Single Family w/attached garage

Project Name/Description

RE: 202 Lane Avenue
(Id# 2002-0125) (Cbl 308B051)

TO: Inspections
FROM: Jay Reynolds, Development Review Coordinator 
DATE: January 30, 2003
RE: C. of O. for #202 Lane Avenue
Lead CBL (308-B-051) ID# (2002-0125)

**MINOR SITE PLAN**  
**SHOWING PROPOSED 2 STORY HOME**  
**AT 204 LANE AVENUE PORTLAND, MAINE**  
**ARCHIE GIOBBI**

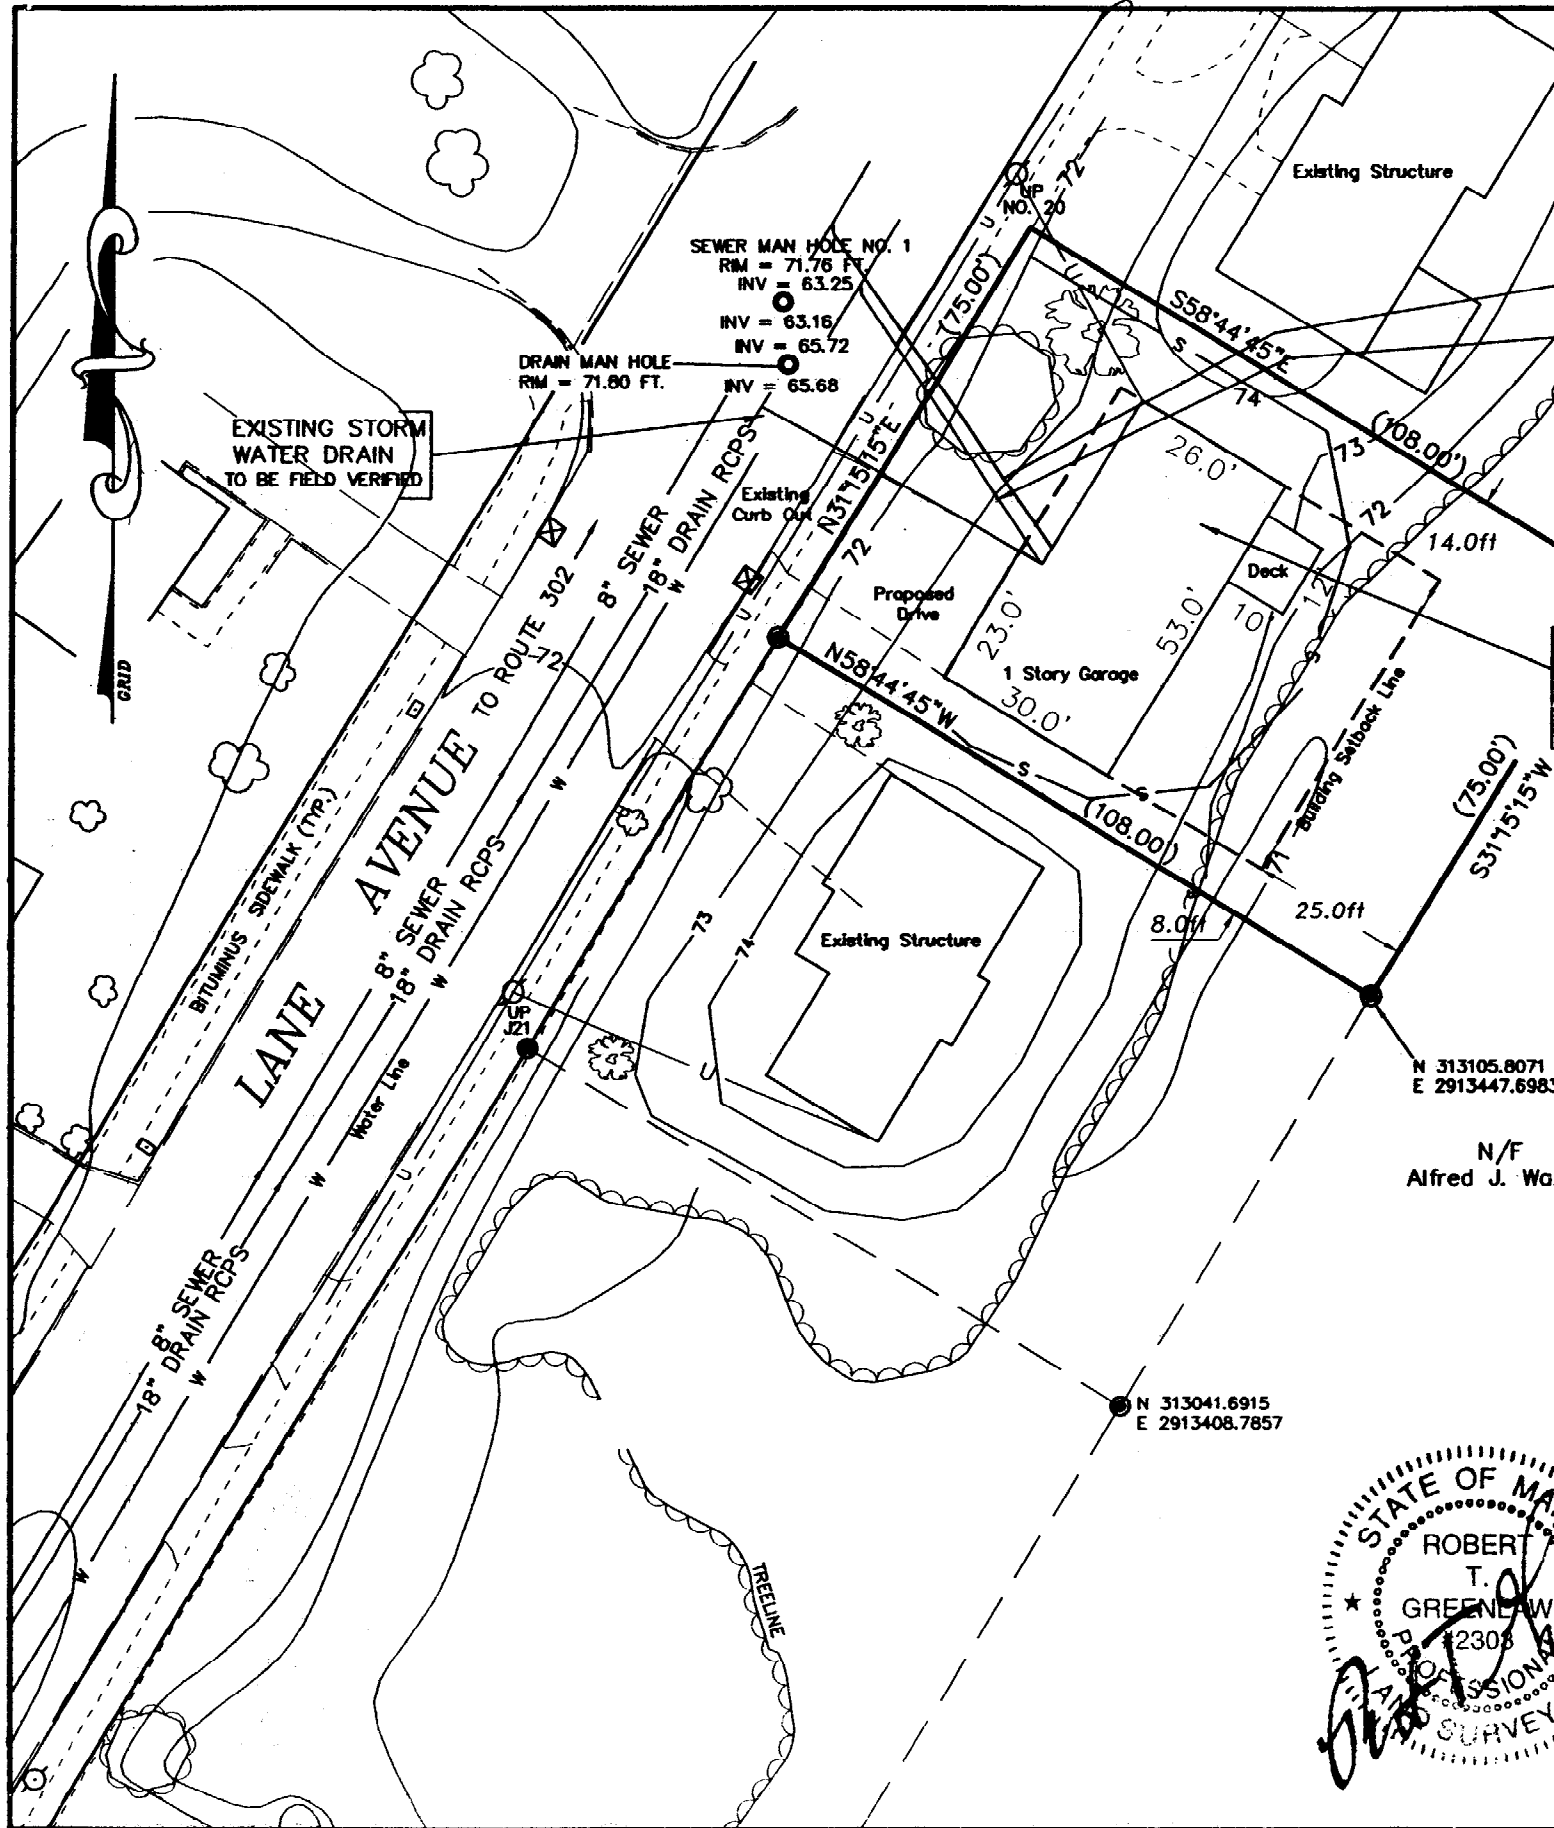
1. Landscaping installation: 2 Street trees along the property frontage as shown on the site plan and as required by Ordinance.
